Subject: LU/7/18/DOC - Land adjacent to Shell Garage, Worthing Road, Littlehampton - Condition 4, SW Drainage

From: Paul Cann
Sent: 22 January 2018 15:42
To: Planning.Responses
Subject: RE: Planning Consultation on LU/7/18/DOC

APPLICATION NO: LU/7/18/DOC

Description of Works: Approval of details reserved by condition imposed under LU/20/17/PI relating to condition 4-surface water drainage.

|           | <b>Soakaway Test Results<br/>(after BRE Digest 365)</b> | <b>Geo-Environmental Services Limited</b><br>Unit 7 Danworth Farm, Cuckfield Road,<br>Hurstpierpoint, West Sussex BN6 9GL<br>+44(0)1273 832972 www.gesi.net |

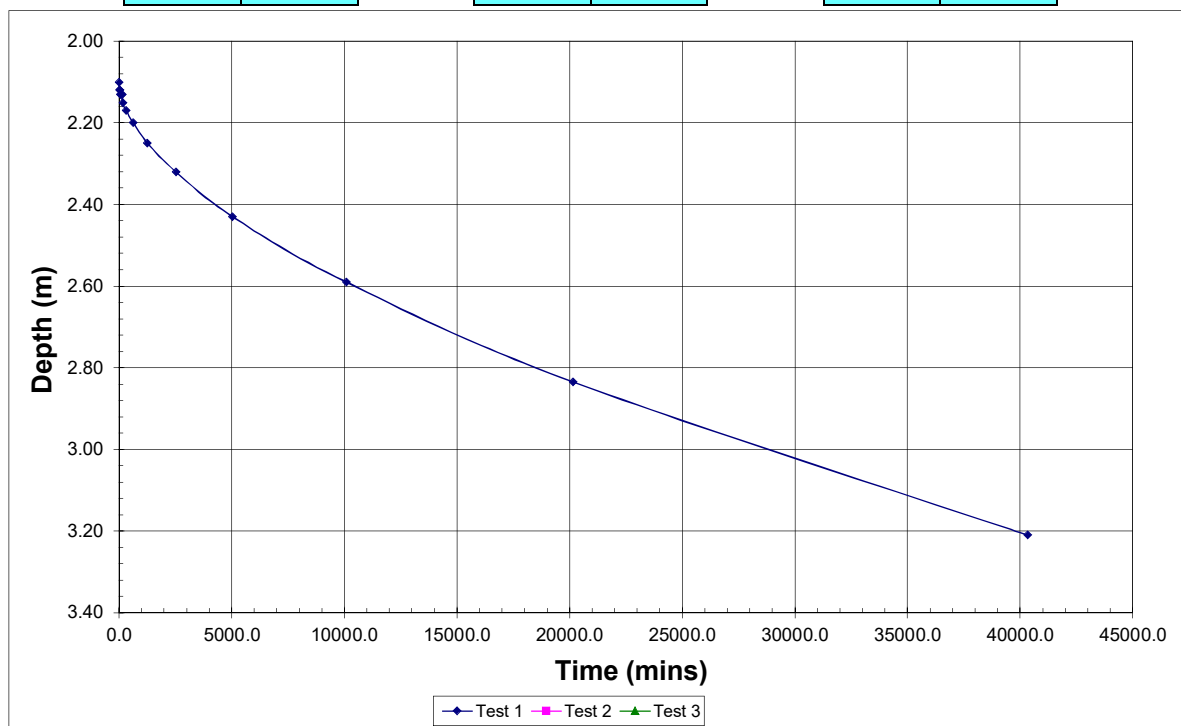
It is noted that the percolation testing/groundwater observations have been carried out in May/June ie. outside the required winter period.

The percolation rate is detailed as 'negligible' however, a rate (m/s) has not specified.

Before the proposals can be considered further, please provide more information on the percolation rate achieved. This will determine if further testing, etc is required. We need to be satisfied that infiltration has been fully investigated before other options are considered.
